Designing Out Crime Scheme

Site Address: The Priory, Whitechapel Road, Cleckheaton, BD19 6HR

Application Ref: 2025/90655

SECTION LOCATION
1:1000

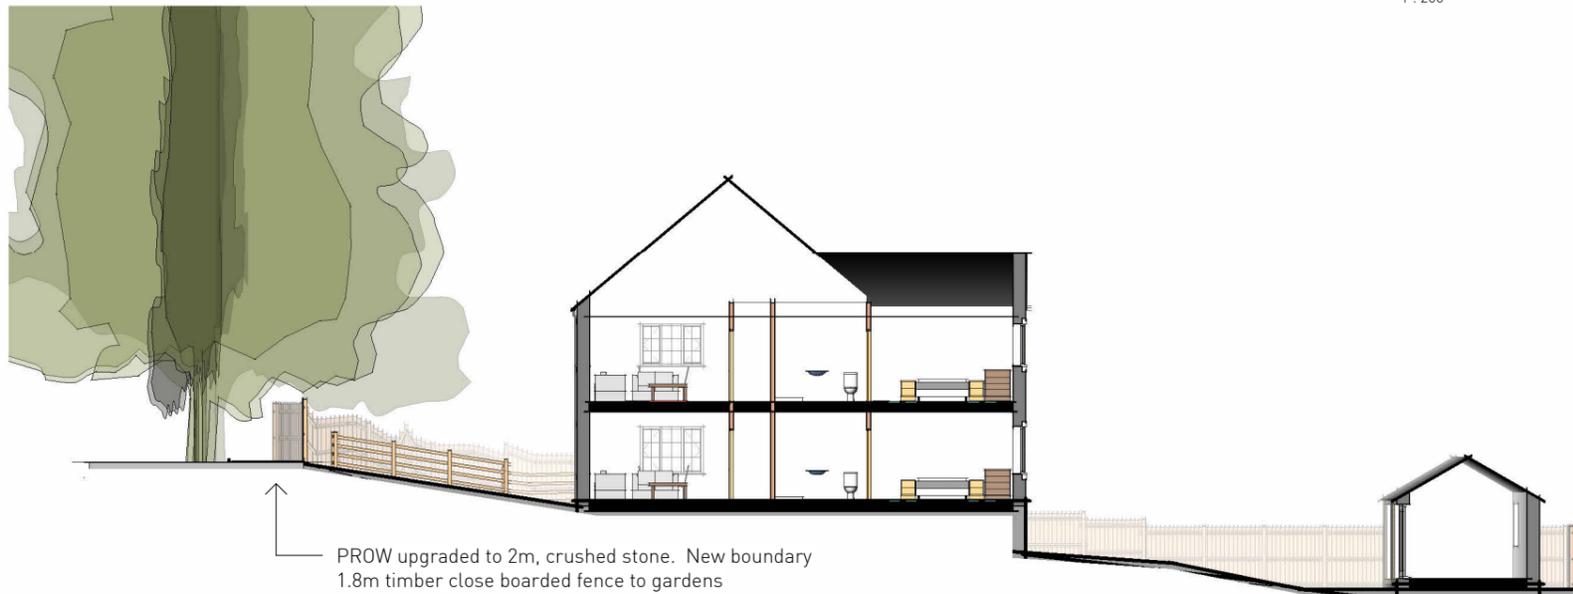
Landscape plan H24-WC, Rev. C mentions that the existing fence to the North and East boundary will be relocated to land ownership boundary. Please confirm the details of this fence (height and material). – A 1.8m timber fence will be installed to provide privacy and security to the development.

GROUND FLOOR
1 : 200

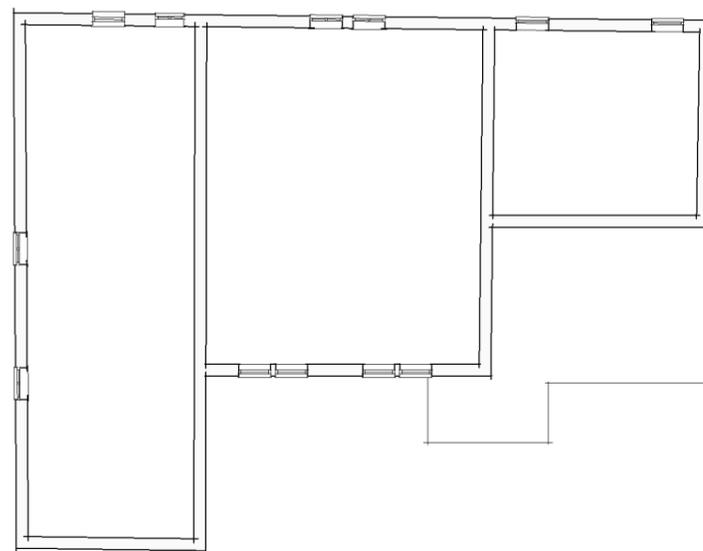
The front of the property (South elevation) features a recessed doorway incorporating 2 apparent hiding places, as seen on ground floor plan H24-WC, Rev. A. Is there any scope to abandon this feature and bring the doorway forward, in line with the rest of the building please? Recessed doorways are proven crime generators. If it cannot be avoided, it has to be mitigated with sufficient lighting and CCTV coverage. – CCTV will cover the site external and be monitored in the staff office which will be manned throughout the day/night.
